# Marine Management Organisation

MMO Reference:  
DCO/2022/00001

Planning Inspectorate Reference:  
EN010121

## Planning Act 2008, Floatation Energy, Proposed Morecambe Offshore Wind Farm

**Figure:** 10.6      **Drawing No:** PC1165-RHD-ES-OF-DR-Z-0038

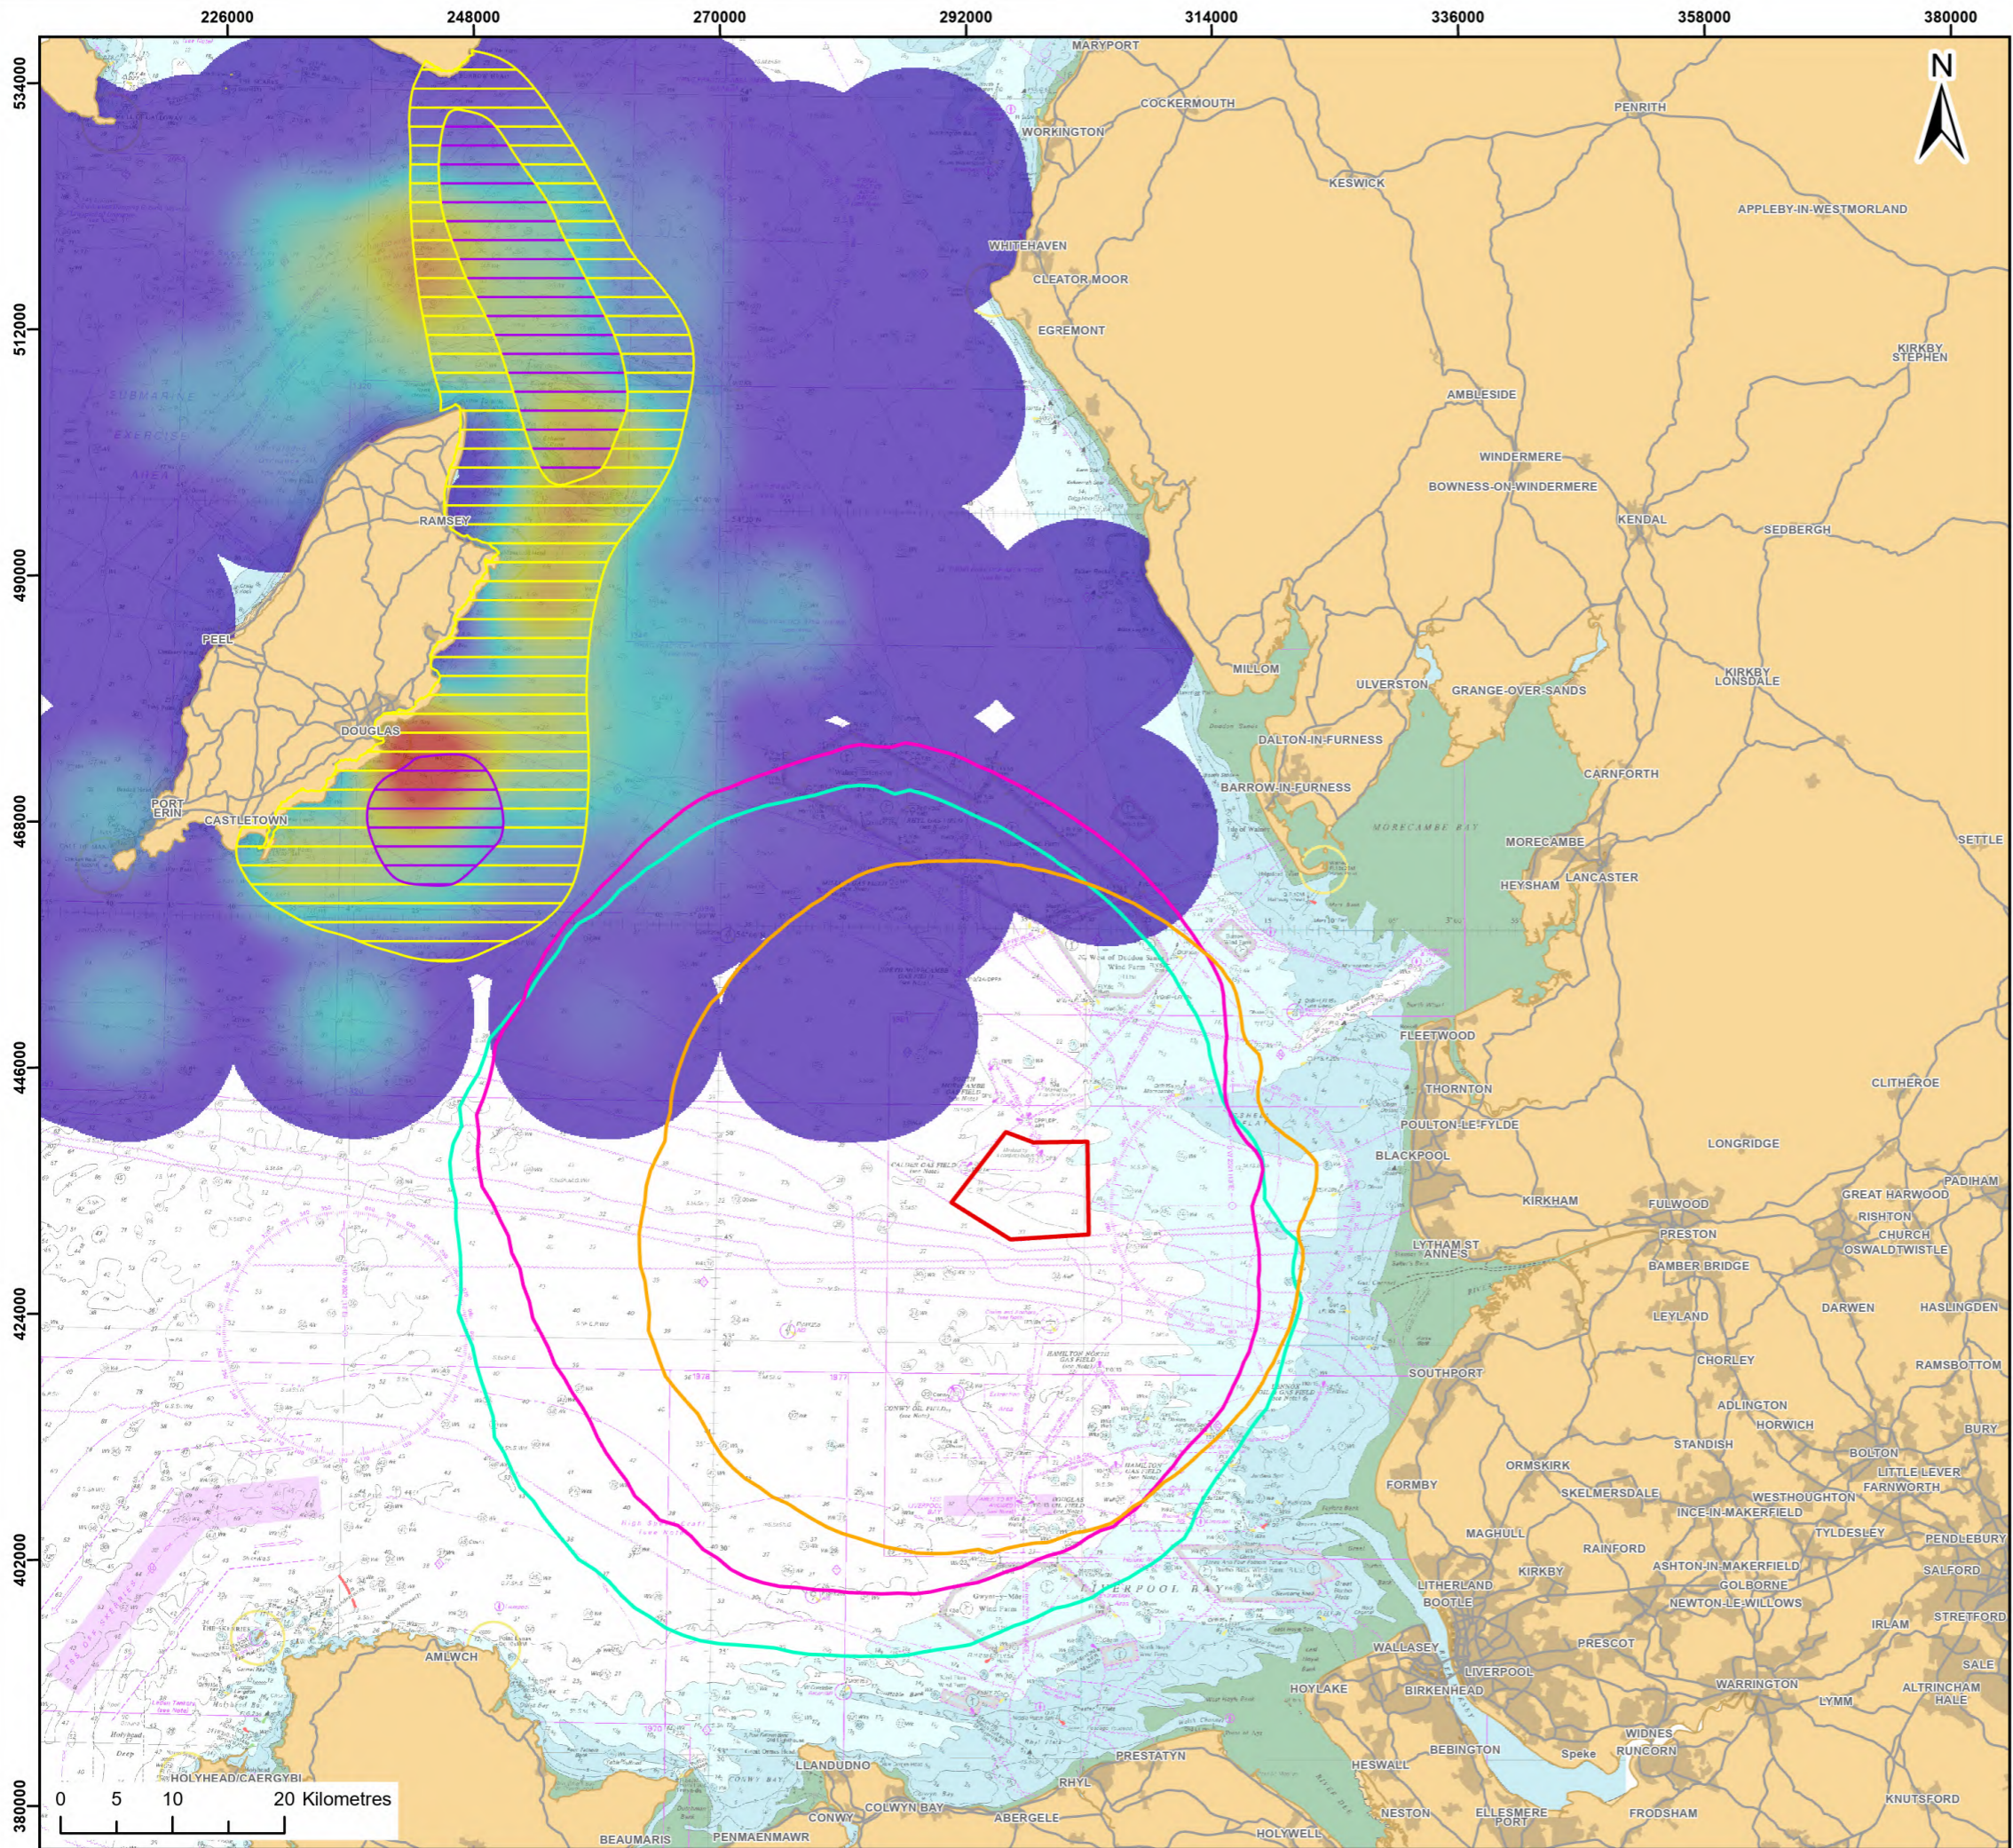
- 3.5.1. Figure 10.6 of Volume 5 Chapter 10 (APP-047) Fish and Shellfish Ecology Figures should be updated for transparency/clarity.
- 3.5.2. The MMO do not support the conclusions made in the CIA (Cumulative Impact Assessment). The MMO would have expected more data to be used. In the absence of such data the MMO requests a piling restriction is in place to avoid the cod spawning period.
